Director – Resources Assessment
Planning Services
Department of Planning & Environment
GPO Box 39
Sydney NSW 2001

23 Nov 2016

Martins Creek Quarry – Environmental Impact Statement (EIS)
Proponent – Buttai Gravel Pty Ltd (Daracon)
Application No SSD-16-6612

Drawing Title
MARTINS CREEK QUARRY
DUKE STREET / KING STREET, PATERSON -
INTERSECTION MEDIAN WORKS

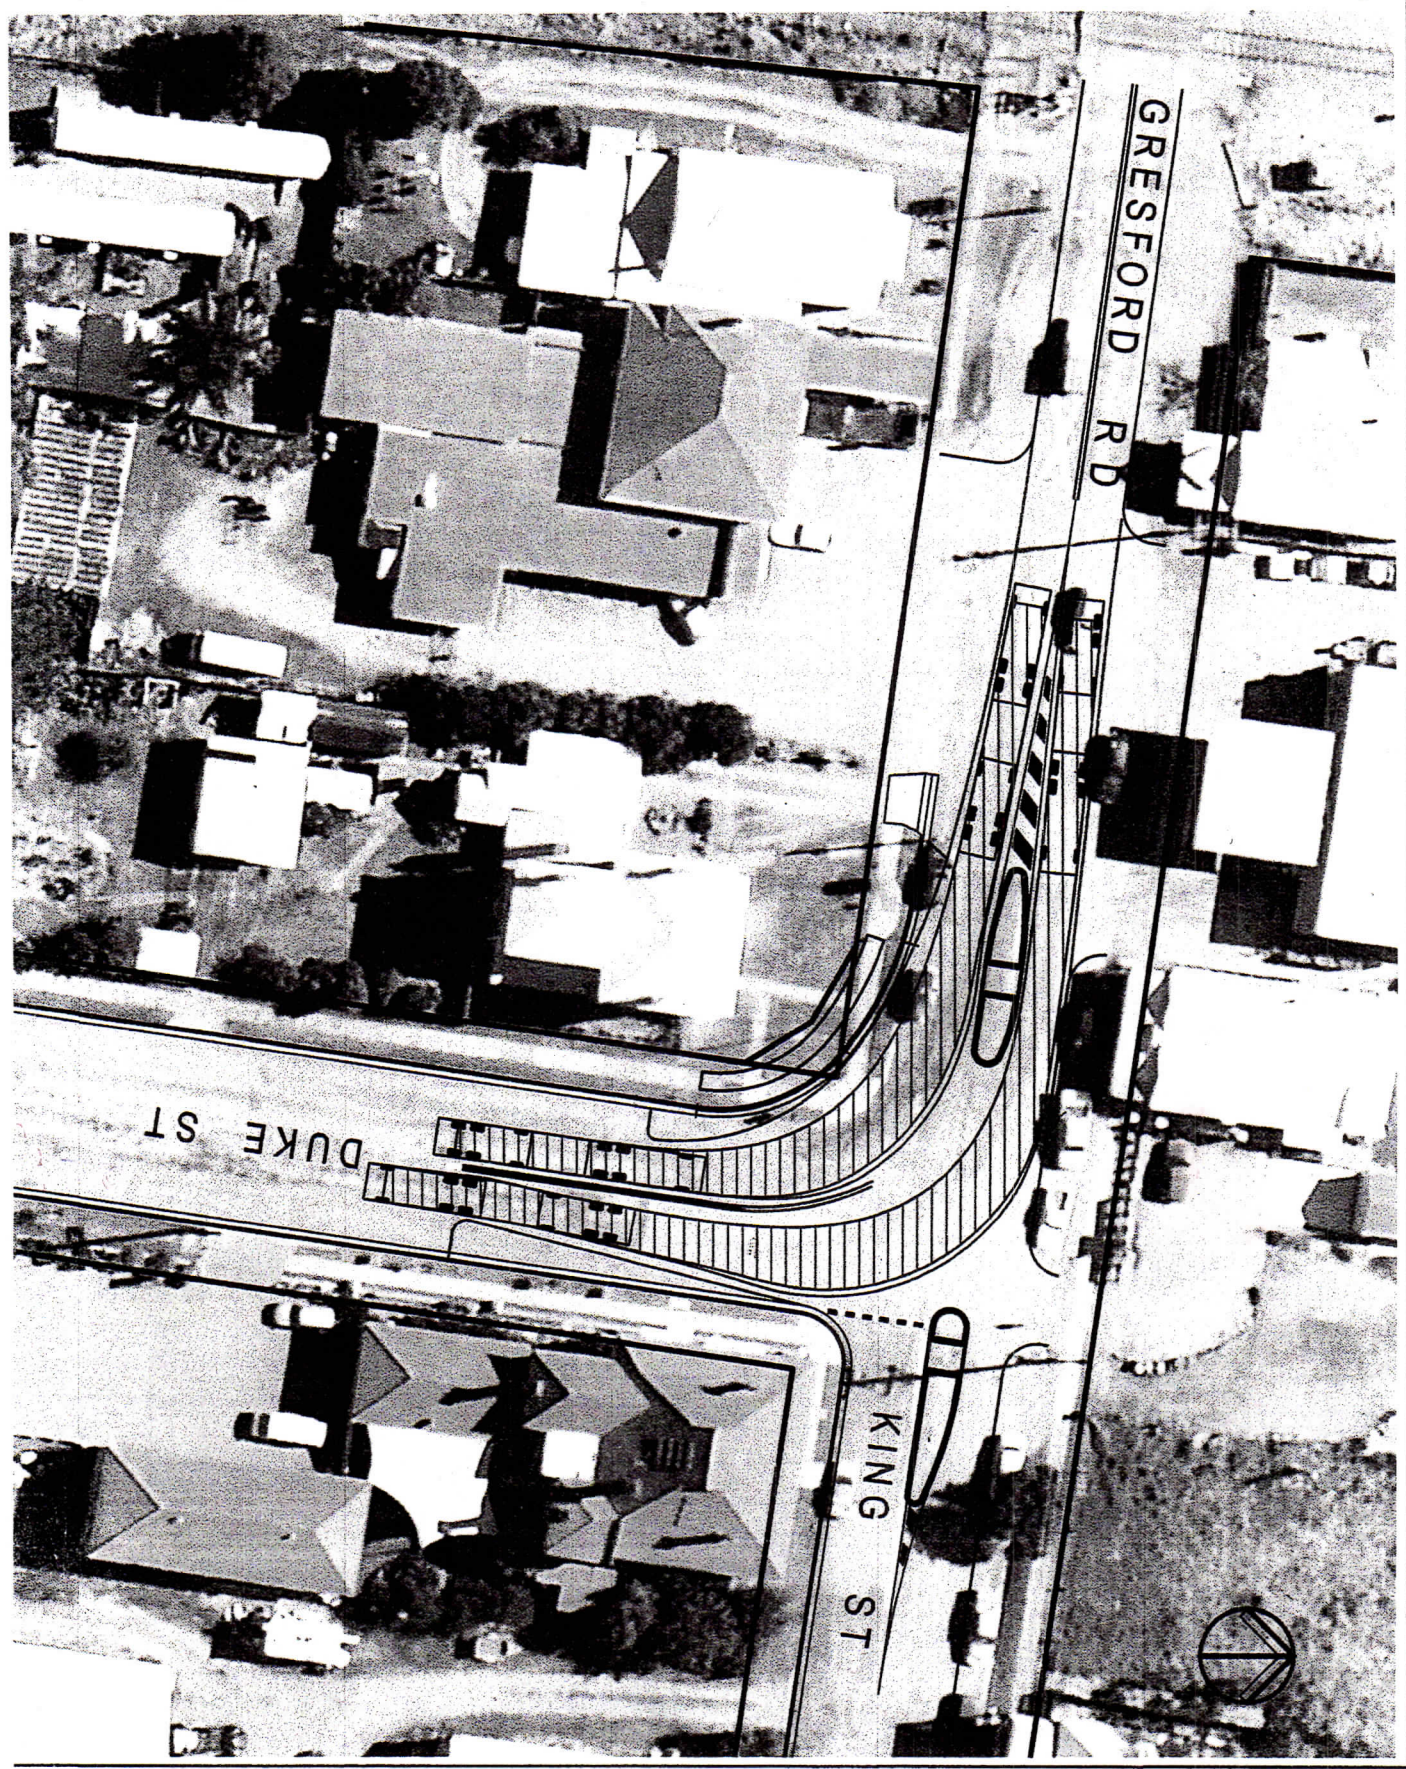
The proposed “upgrade” to the Duke St/King St junction will have serious negative consequences for the village. Apart from looking like it was designed and drawn by a 10 year old and assumes the acquisition of privately owned land, these are:

- Removes access and parking from several key businesses in the village namely the Post Office, Service Station and Country Café.
- Will make crossing the road for pedestrians more difficult than currently
- Will have a detrimental visual impact on the village
- Is detrimental to the heritage value of the surrounding buildings
